Jeanie Bourke - RE: 10 Exchange St., BP#2015-00157 plan review comments

From: Jeanie Bourke [mailto:JMB@portlandmaine.gov]
Sent: Friday, May 15, 2015 1:58 PM
To: Liza Gonzaga; LL0740@yahoo.com
Subject: 10 Exchange St., BP#2015-00157 plan review comments

I am doing the building/plumbing code review for this permit, and have some questions:

LS01

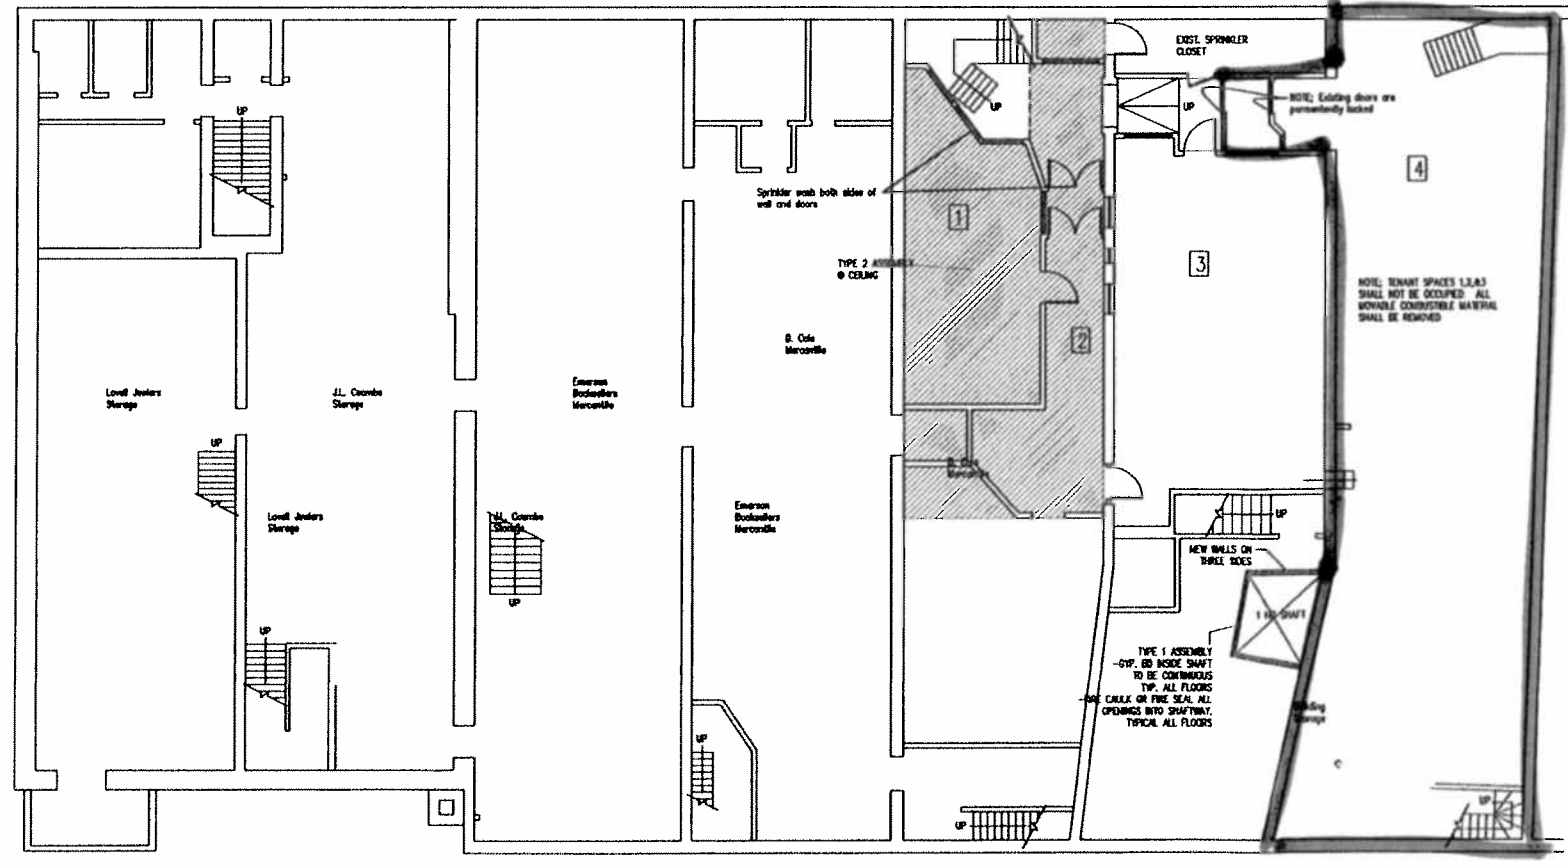
1. The floor plan does not indicate if there are bathrooms in this space. Please let me know the location of these.
2. Were sink fixtures & plumbing pipes installed for the salon?

There is a bathroom. It's a single stall and its behind the room with the utility sink.

Yes I did have a plumbing permit. There were no pipes added all of the plumbing was there the sinks were just hooked up. They are not permeant fixtures in the building they can be moved they are not attached to the wall. I never saw and inspector come in. I am not there all of the time.
